From: Carrillo, Abiel X.
Sent: Tuesday, December 27, 2016 4:33 PM
To: 'daube@designgroupnm.com'
Subject: APS East Side Family School - G17D19A - Stamp Date 12-12-2016

Based on the information provided in your submittal dated 12-12-2016, received 12-12-2016, the above-referenced Grading and Drainage Plan cannot be approved for Building Permit until the following items are addressed:

PROJECT TITLE: APS Family School East Side

ZONE MAP/DRG. FILE #: G-17-DO19A

E4 WIER DETAIL
SCALE: 1" = 4'-0"

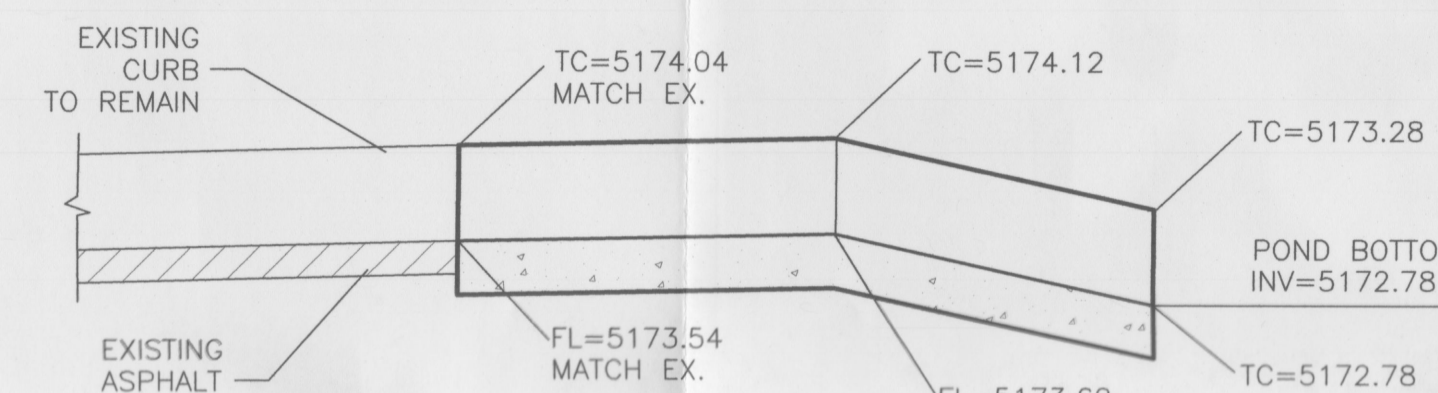
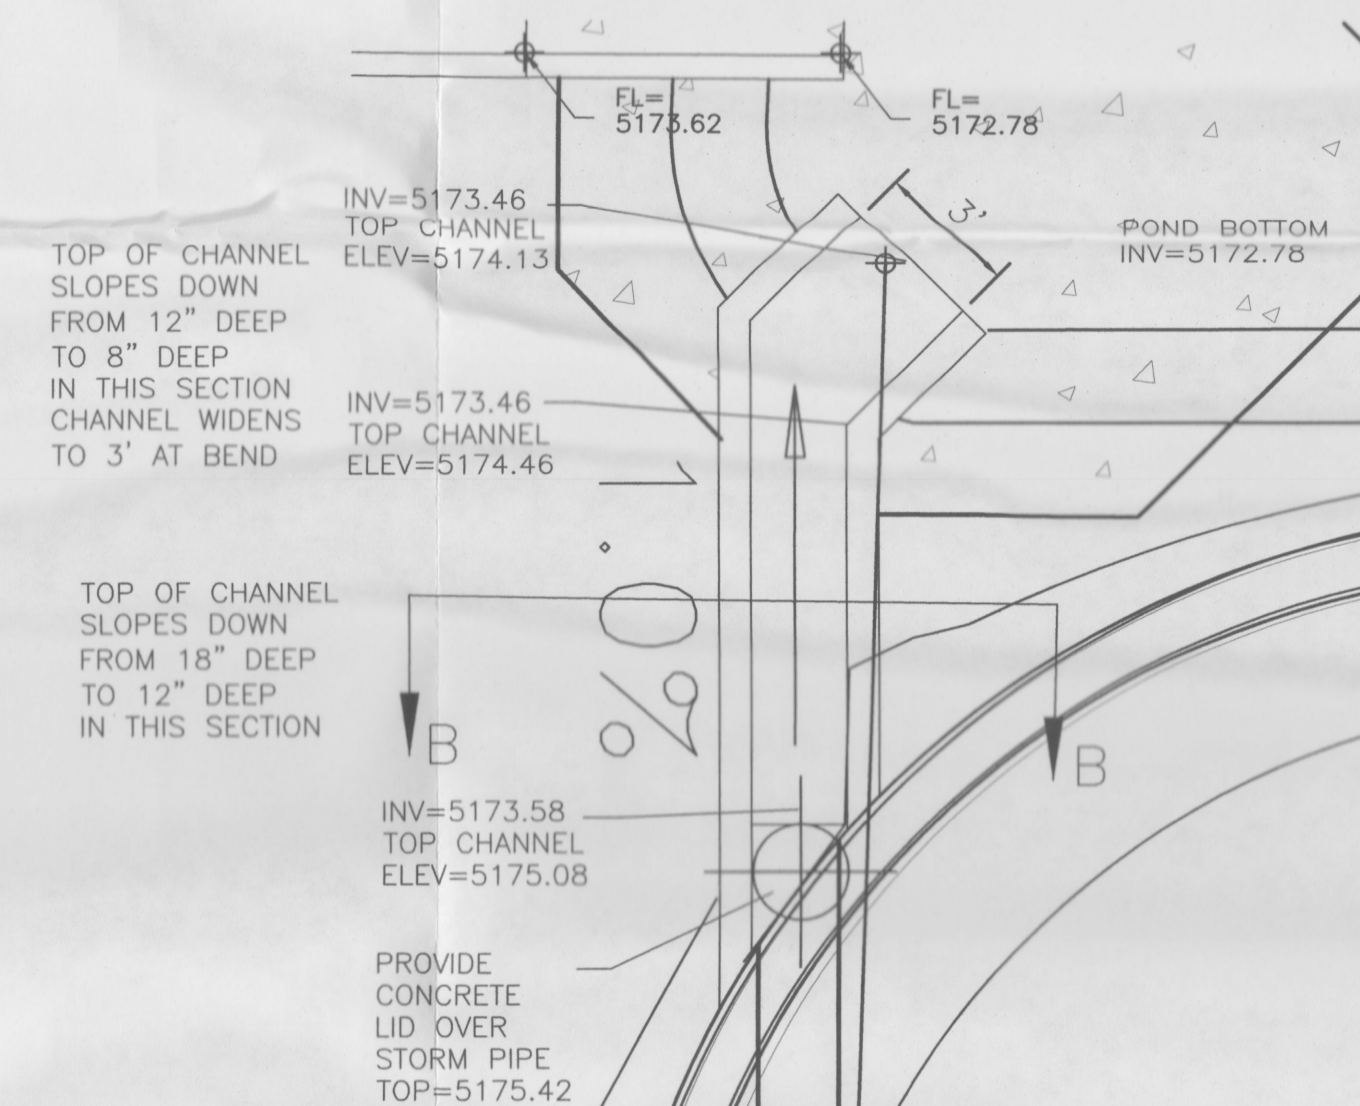
8. Clarify on the plan with details/notes how the storm drain outfalls through the wall. RCP Class IV should be considered under the wall.
9. Provide information for the overflow rundown/weir from the above-mentioned pond (invert elevation, tie-in elevation).

SHEET TITLE:
**SITE
DRAINAGE
PLAN**

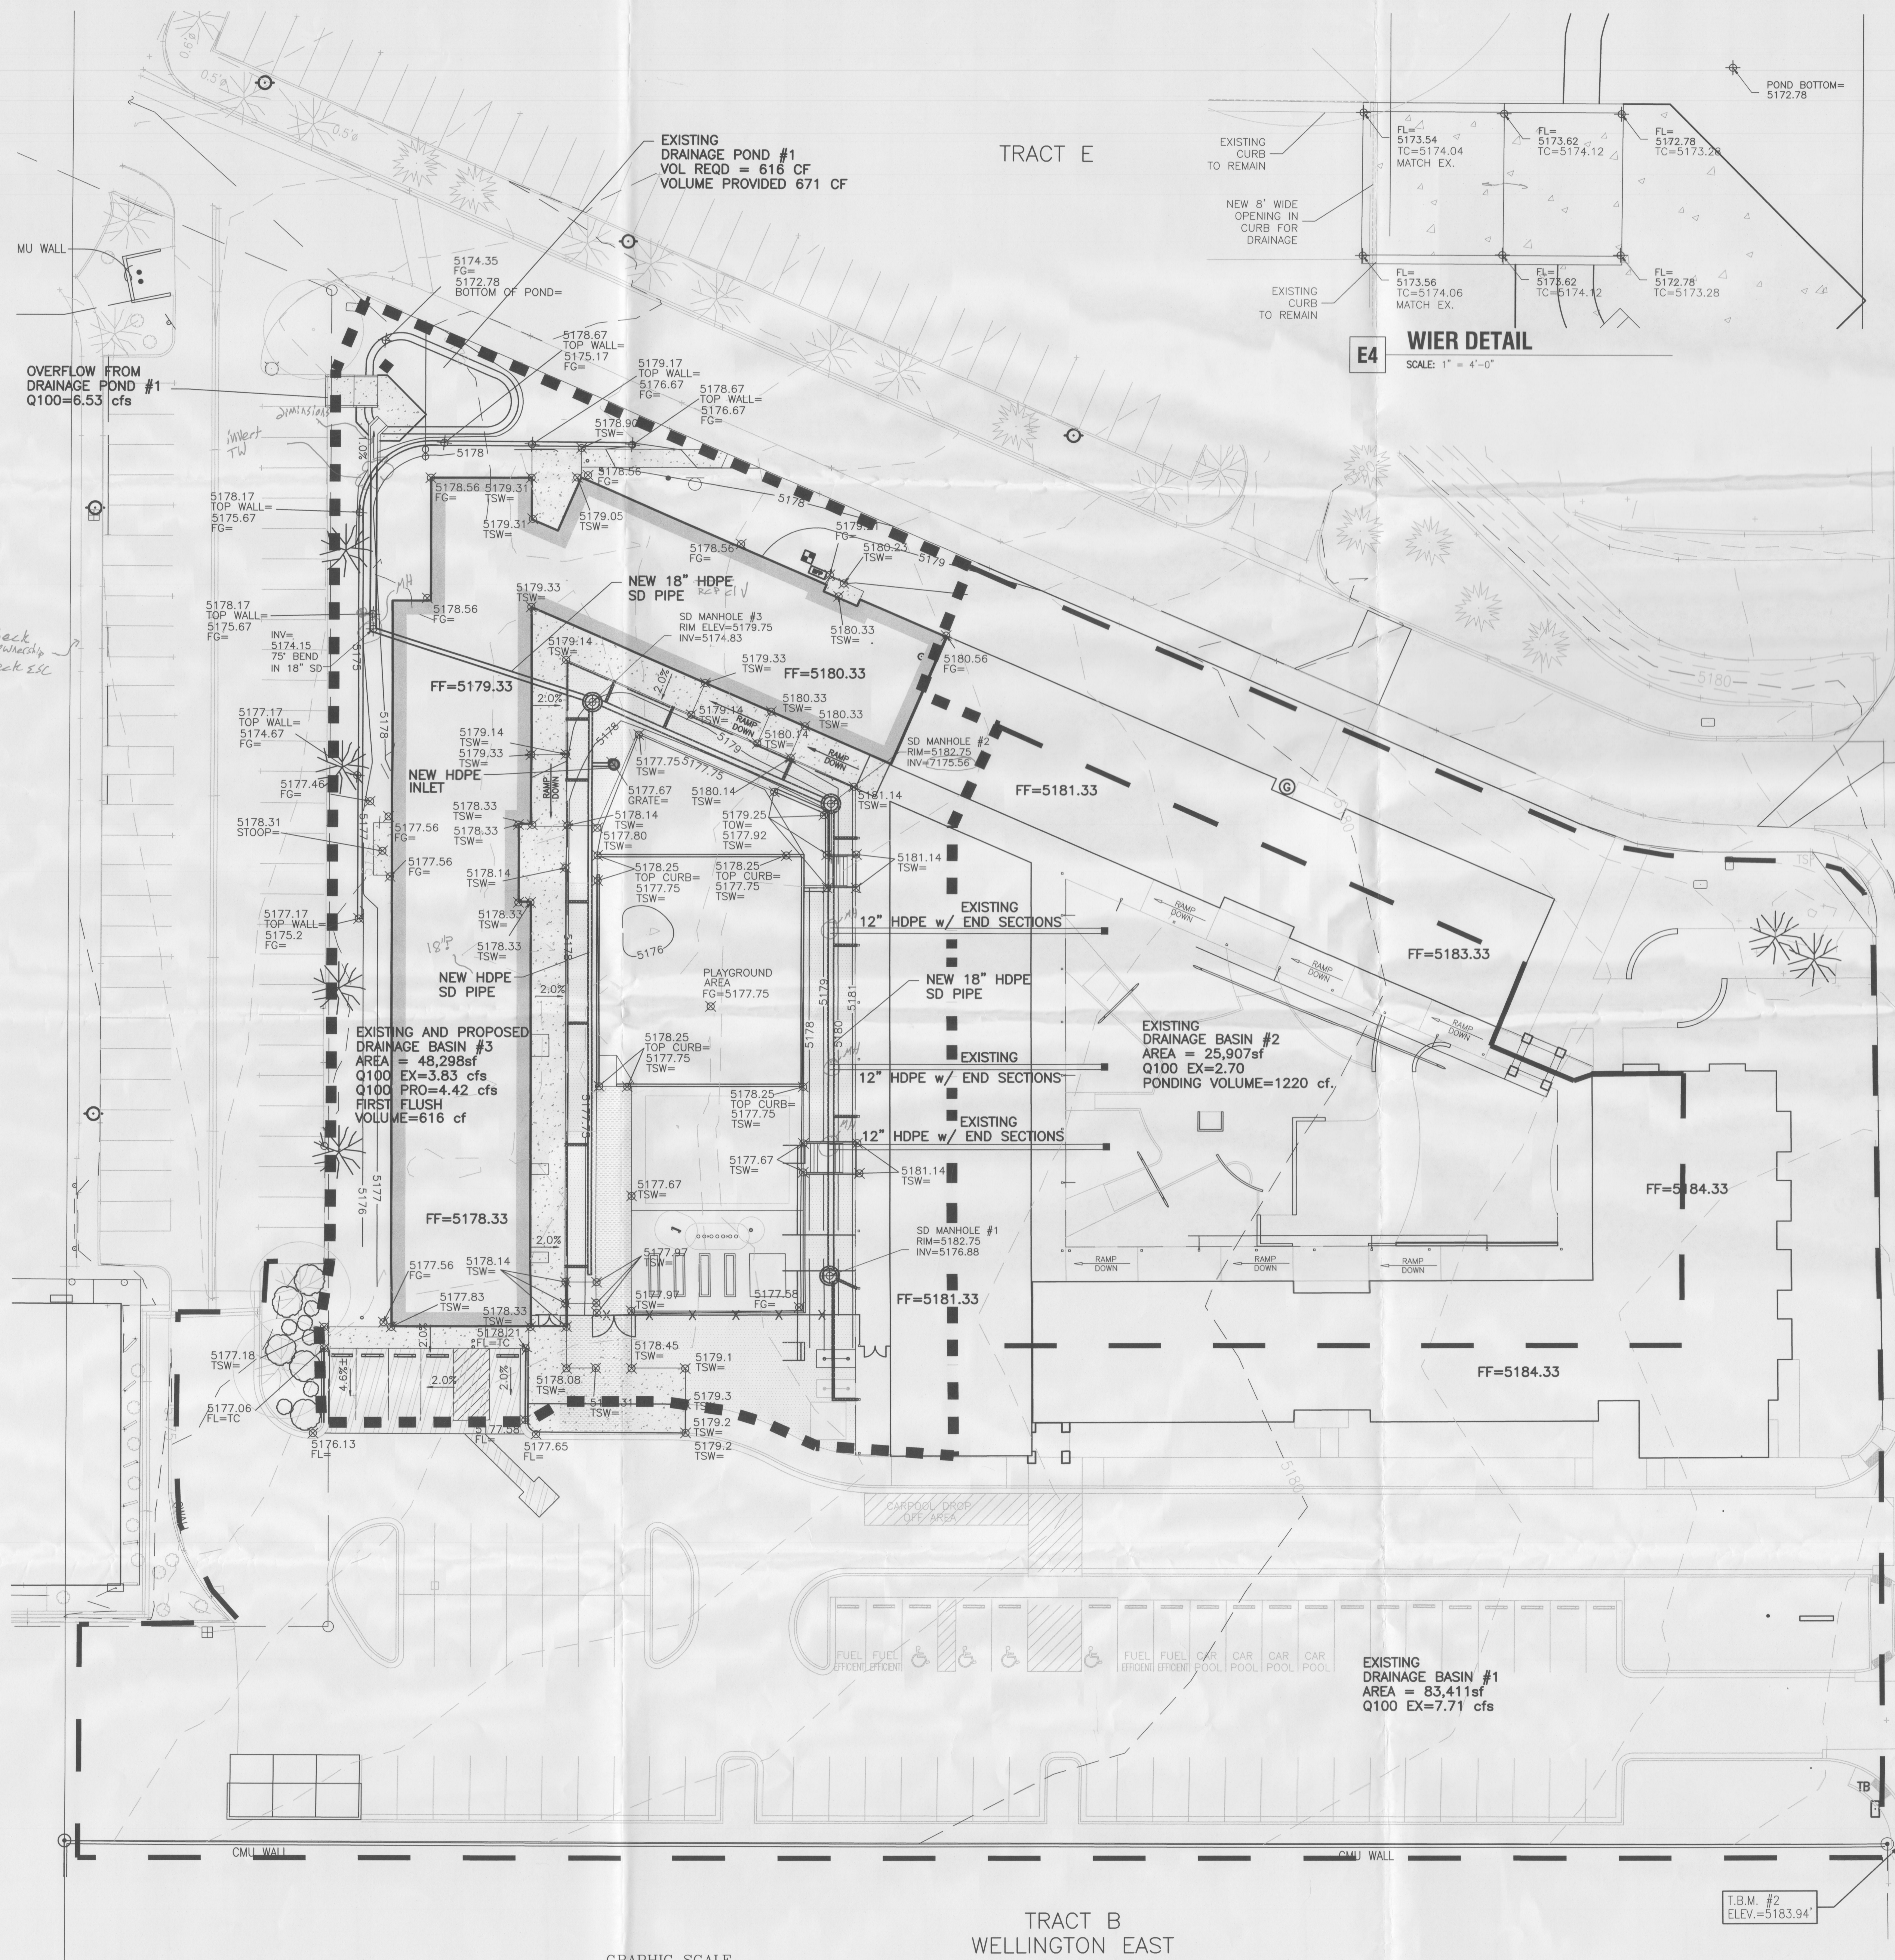
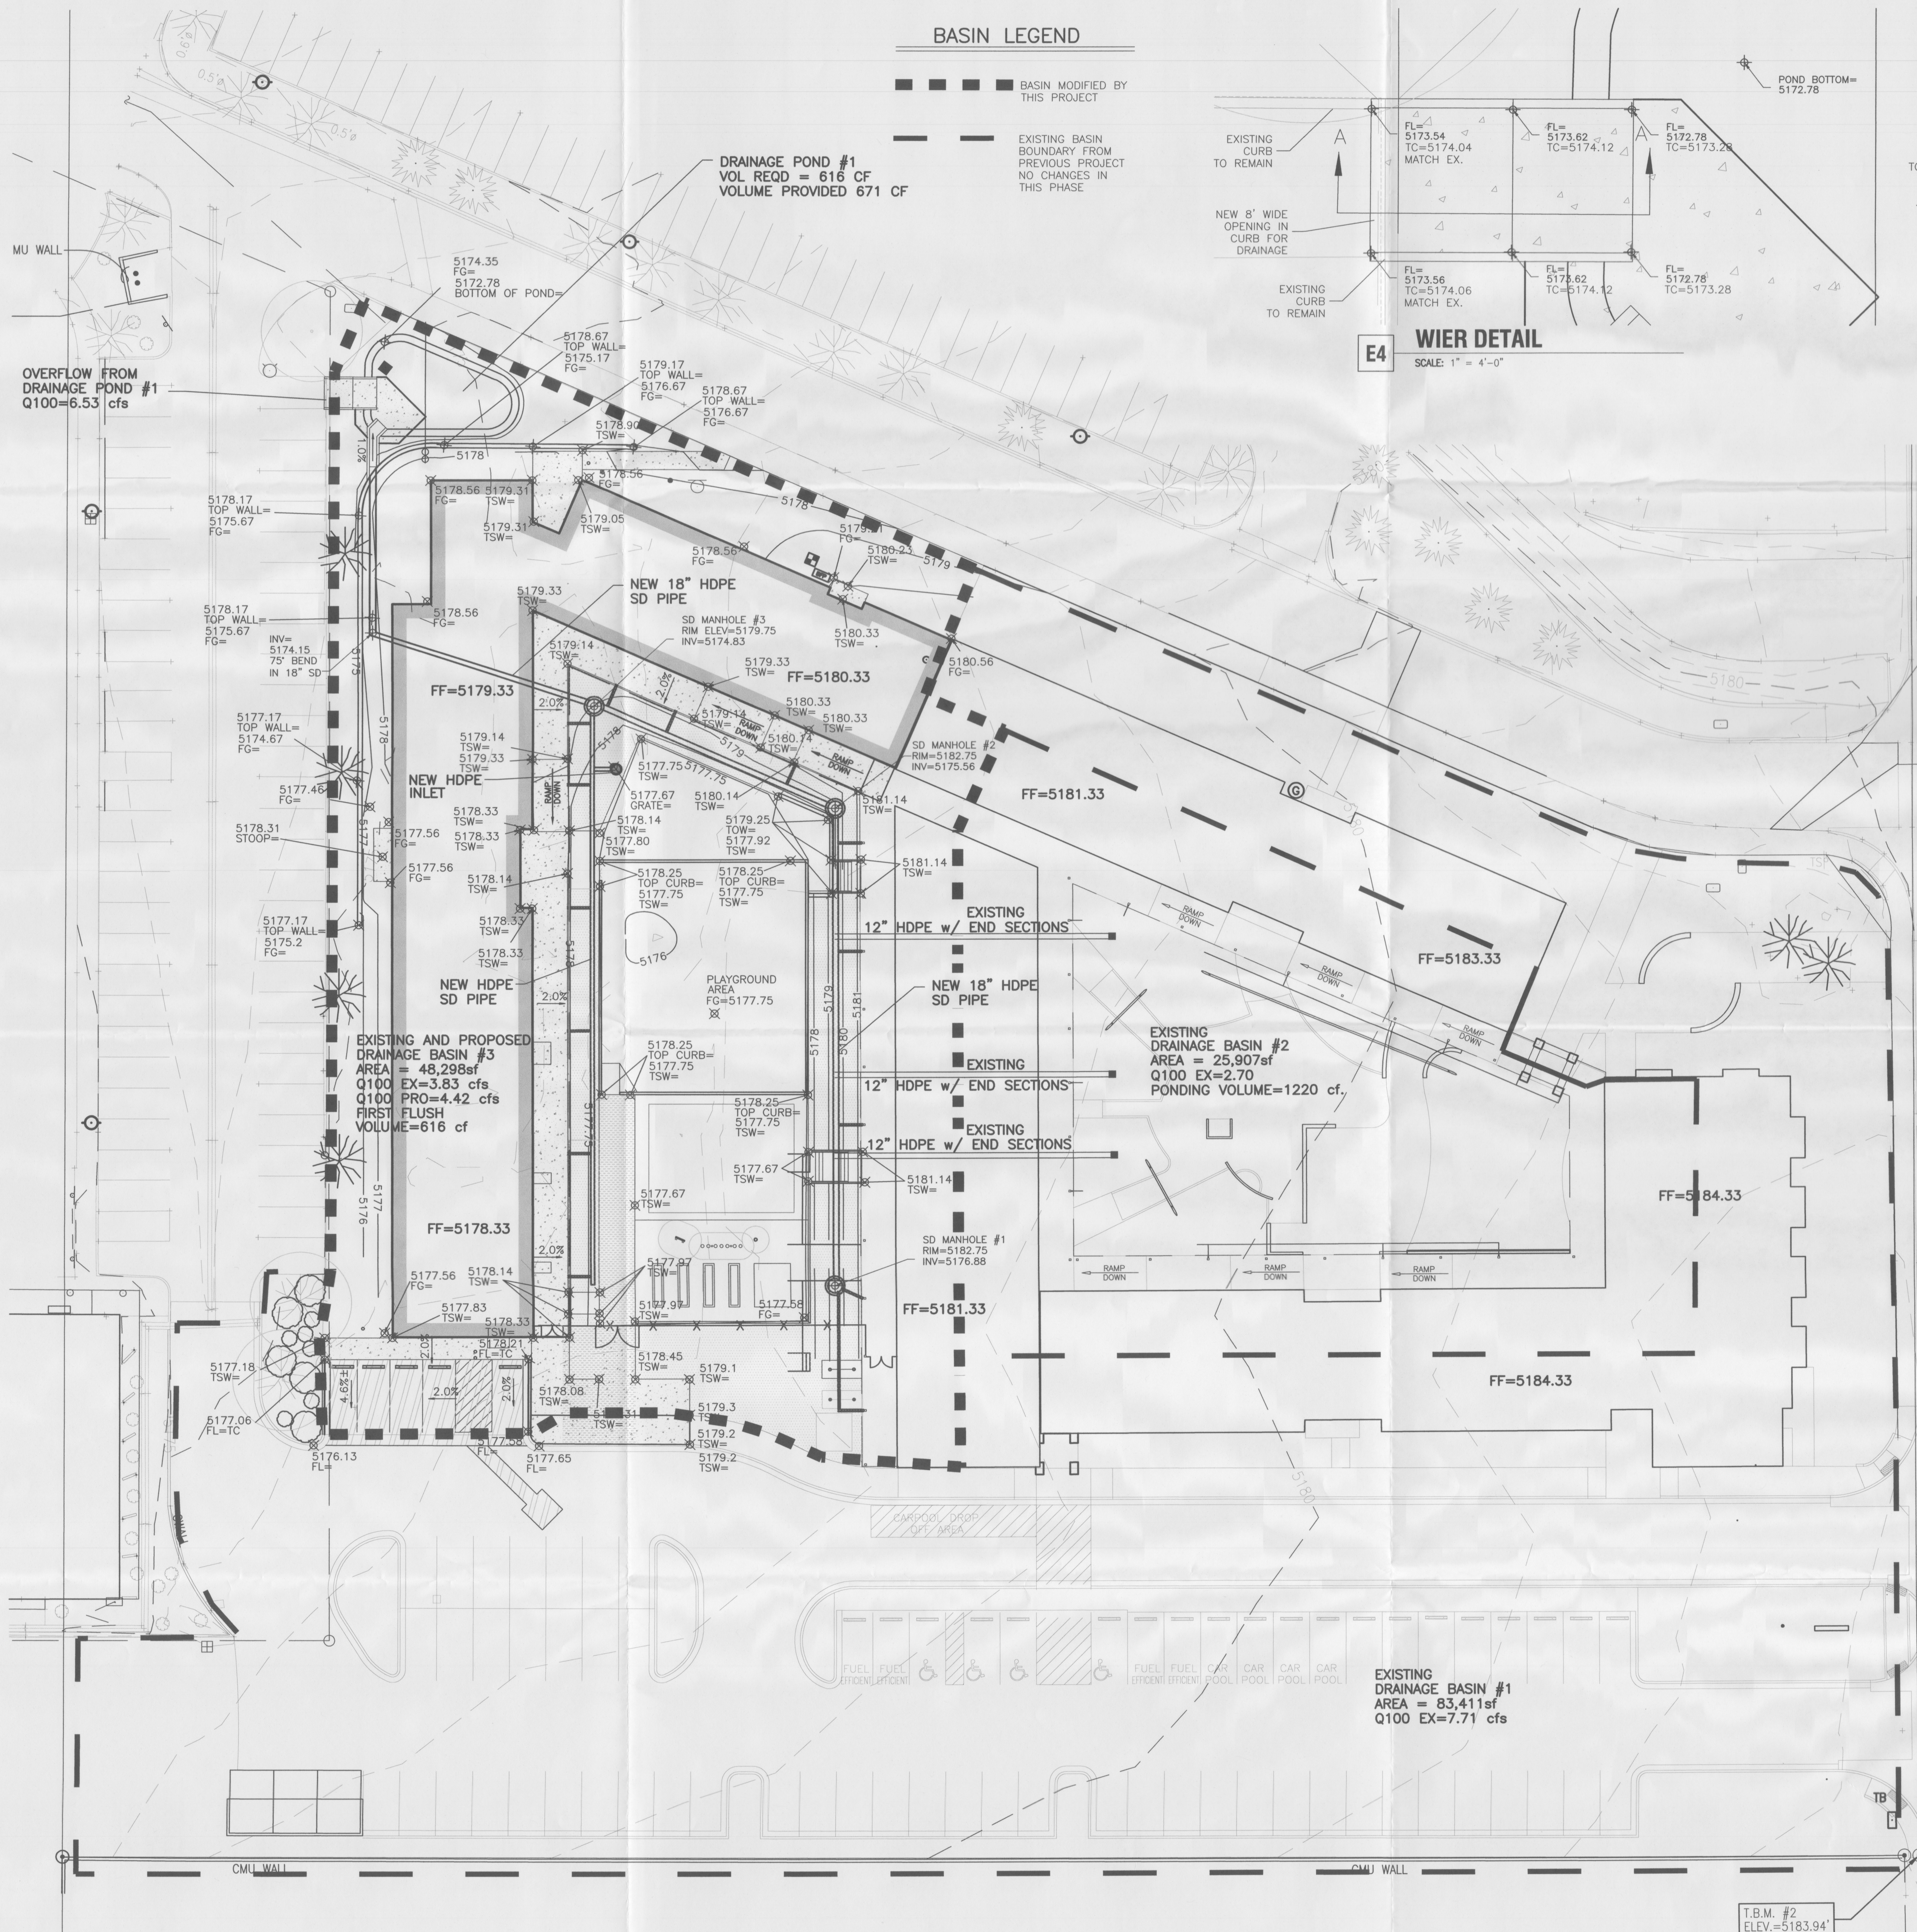
1. In general, clarify in the report and in the plan what is existing and what is proposed.
 - a. The Plan shows bold line work, which implies new facilities/infrastructure, for the entire site. It is not clear where sidewalk, curb, etc ties to existing improvements built with Phase I.

2. Provide proposed Finished Floor elevations for all proposed buildings.
3. Tabulate the assumptions that are used for the inputs in the calculations, mainly the land treatment acreages/percentages and first flush calculations.

- b. Generally label the water quality/retention ponding that already exists in the courtyard (EX Inlet, EX Water Q Pond, etc.).
4. Provide a legend for the Plan showing major existing and proposed features.

5. Clarify the company-specific (?) acronyms that are shown throughout the plan, such as HCS, BNH, LS, DCO, etc. They can be removed or otherwise noted if they are needed for Hydrology's review.

6. There are keyed notes (?) on the plan but no build notes.
7. It is not advisable to propose a storm drain under the new building. It also appears to only be 5' deep under the building, which could impact or be in the way of the foundation structure.
